Your Ref:
Our Ref: AB/147/08/
Please ask for:
Mr J Smith

25th November 2008

Change of use from shop (A1) to domestic garage (C3)
70A Tarrant Street Arundel

BLOCK PLAN

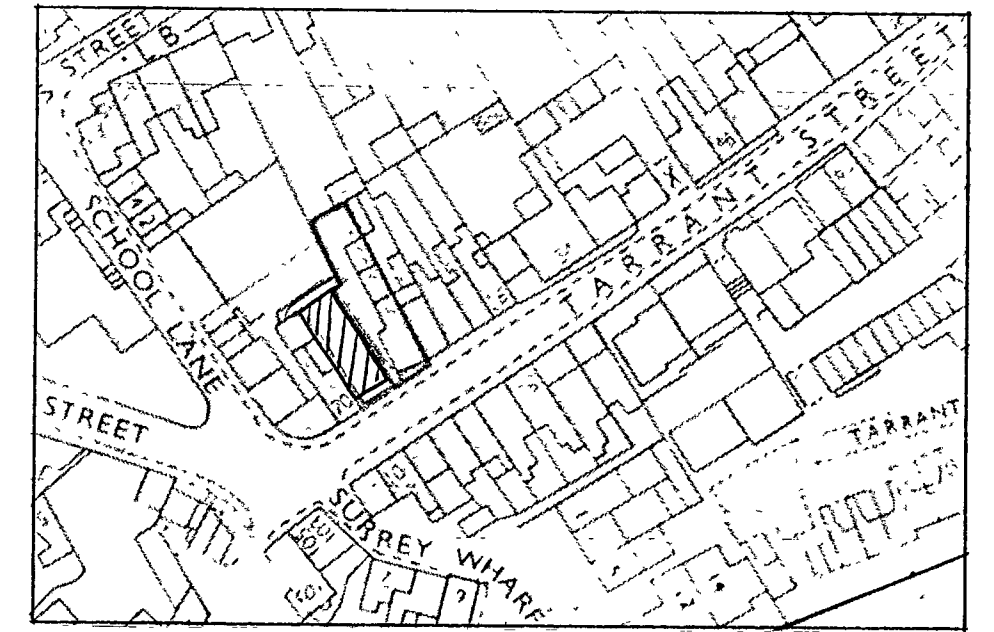
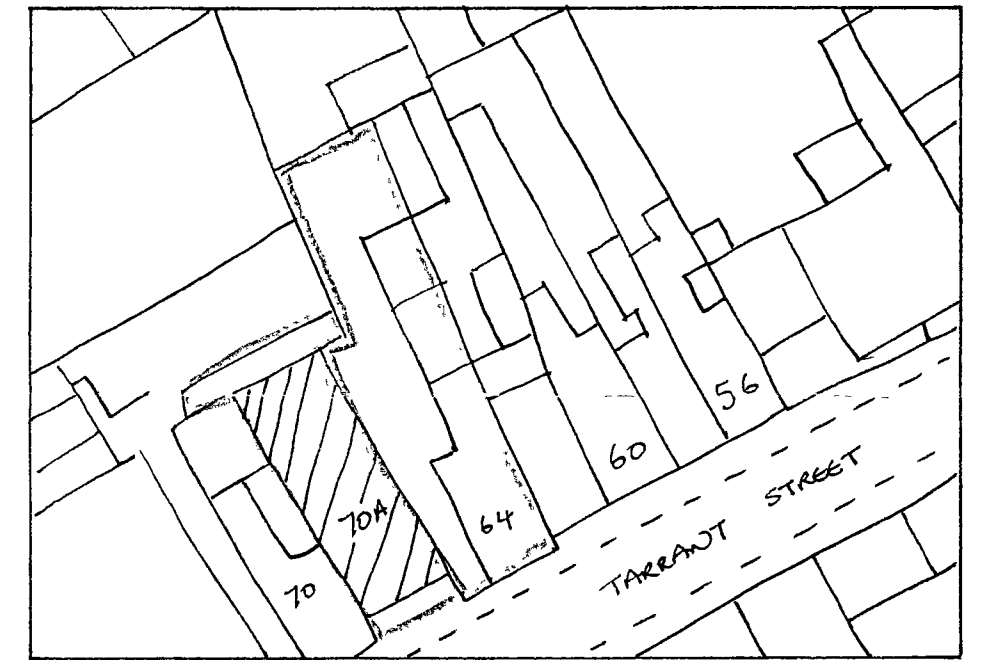
The Arundel Town Council Planning Committee objected to the application on the grounds that the use of the access to the development would cross part of a well used pavement and result in conflict with, and cause potentially dangerous conditions for, pedestrians. Its unsympathetic design and such an inappropriate use would also be out of character and appearance with its surroundings. □
